From: Phil Brady 
Sent: 14 September 2018 08:47
To: Simon Davis
Subject: Planning Application FP/171/18/PL

I was advised that you were the right person to communicate with about this Planning Application.
Can you please add the following concerns to my previous objections already posted on your website on 6th September 2018, in relation to this application.

SITE LAYOUT

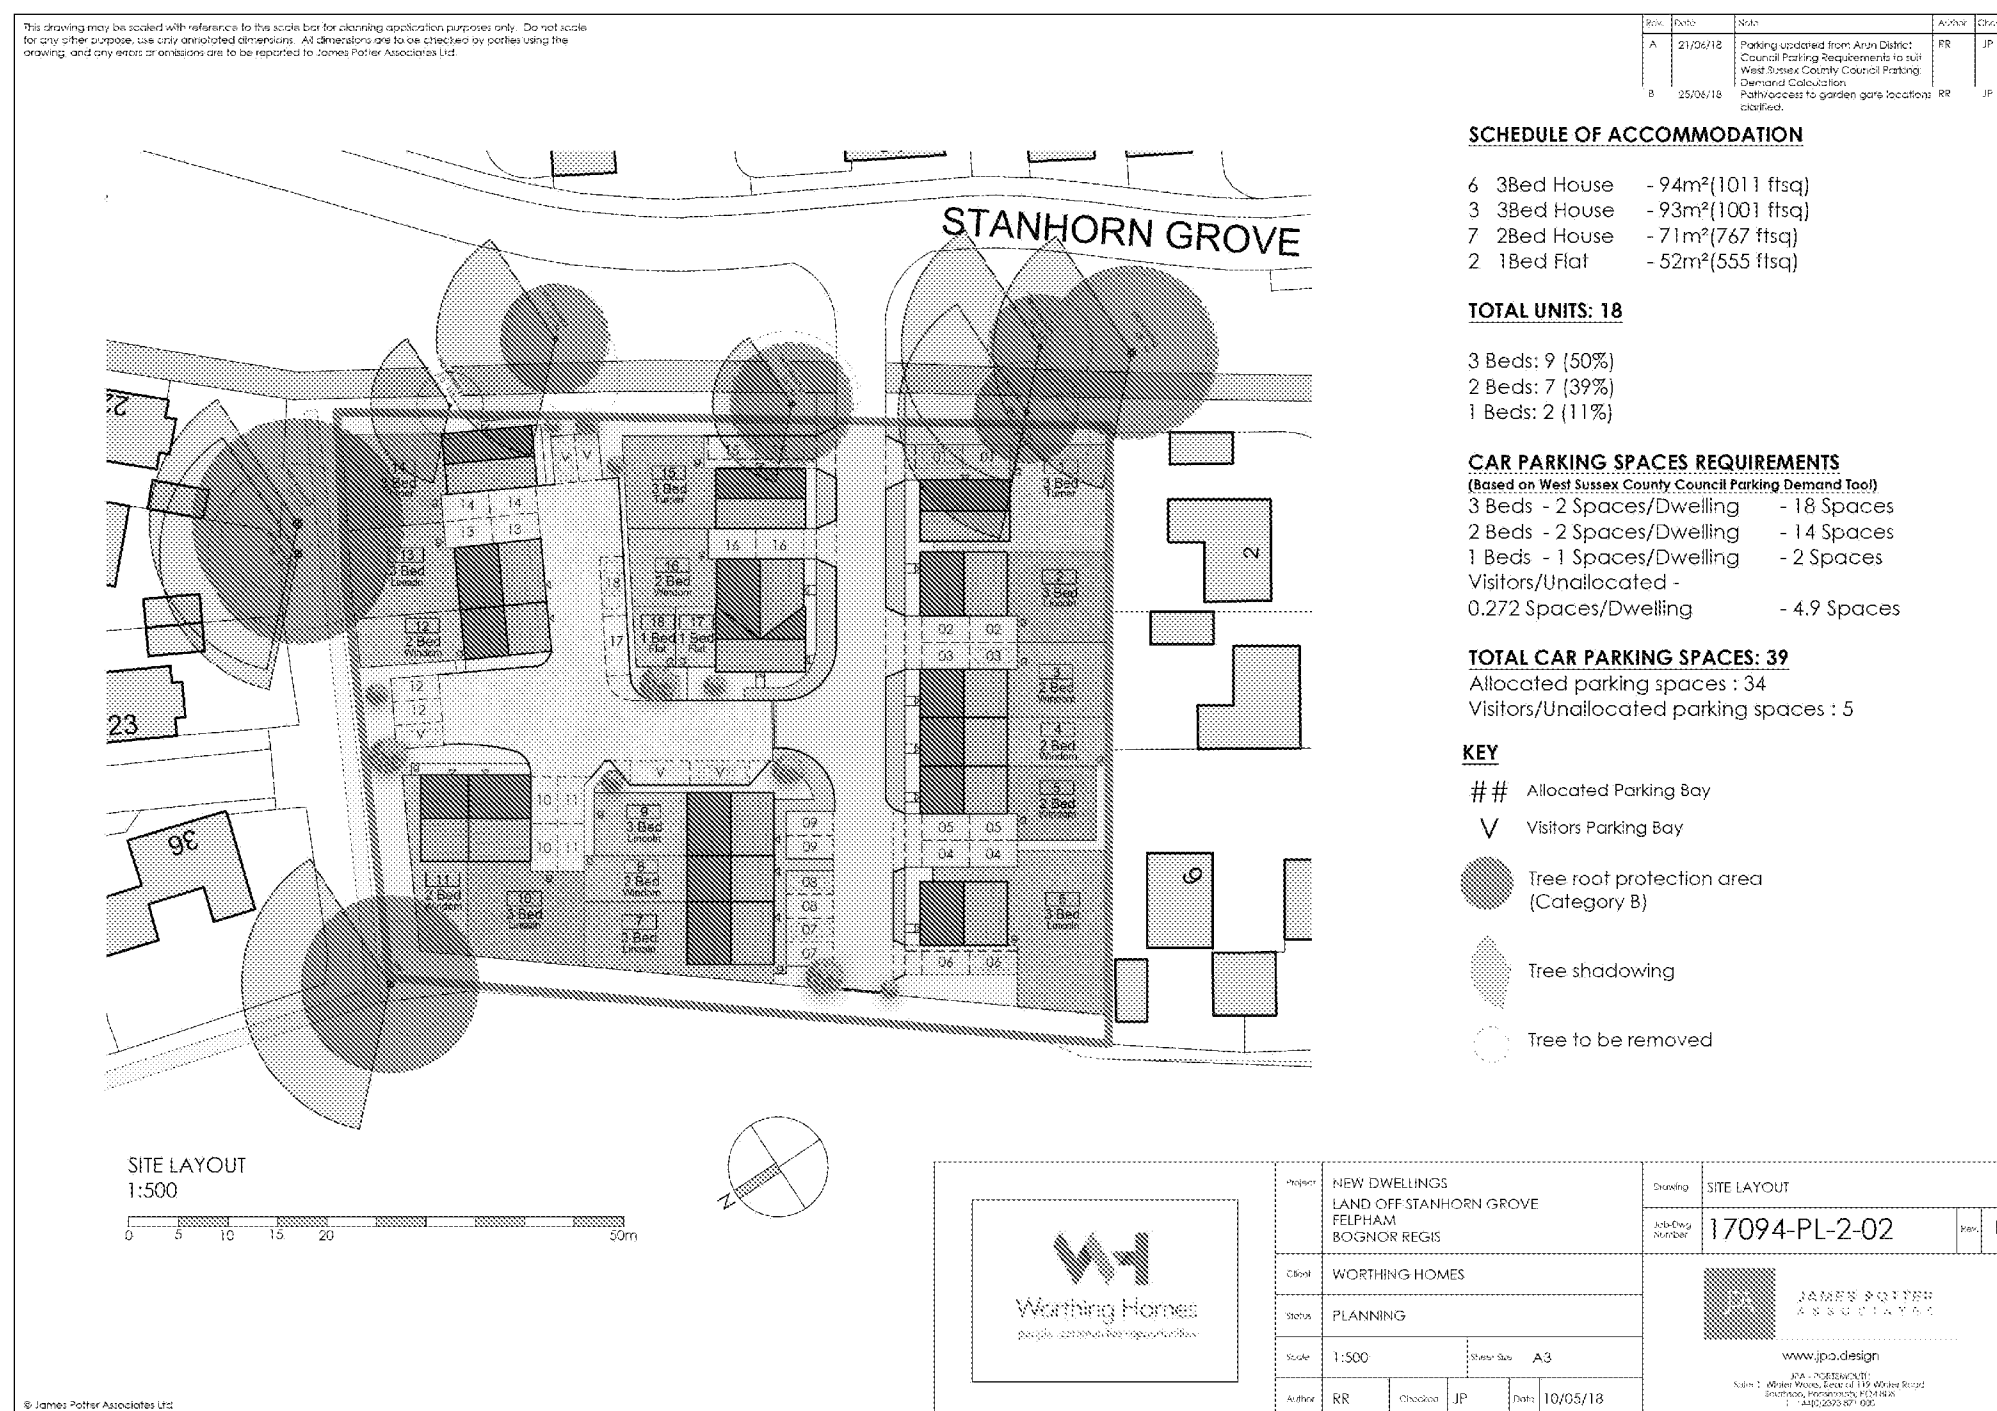
I read through the Ecological Assessment (Sept 2018) recently posted on the website, and noticed a comment on page 37 section 6.6 about an ecological buffer strip.
This refers to a 5 metre strip around 3 sides of the proposed plot. This does not seem to have been taken into account on the various aerial views of the proposed development, I have seen on the Planning Statement submitted by the developer.

Also the Ecological Assessment states in an earlier section, that the plot size is about 0.4 hectares. I have carried out some measurements and found that the usable size of the plot is about 70 x 56 metres and this confirms that 0.4 hectares seems correct. The submitted Planning Statement quotes 0.49 hectares as the size of plot.

The area taken up by the 3 buffer strips would be about 0.09 hectares, so this leaves the buildable area on the plot at about 0.31 hectares (0.40-0.09).

Again the submitted Planning Statement states that the housing density proposed is 36dph for 18 dwellings based on 0.49 hectares area, whereas the actual housing density could well be as high as 58dph with 18 dwellings on 0.31 hectares.

To maintain the 36dph density claimed in the Planning Statement, the dwellings should be reduced from 18 to 11.
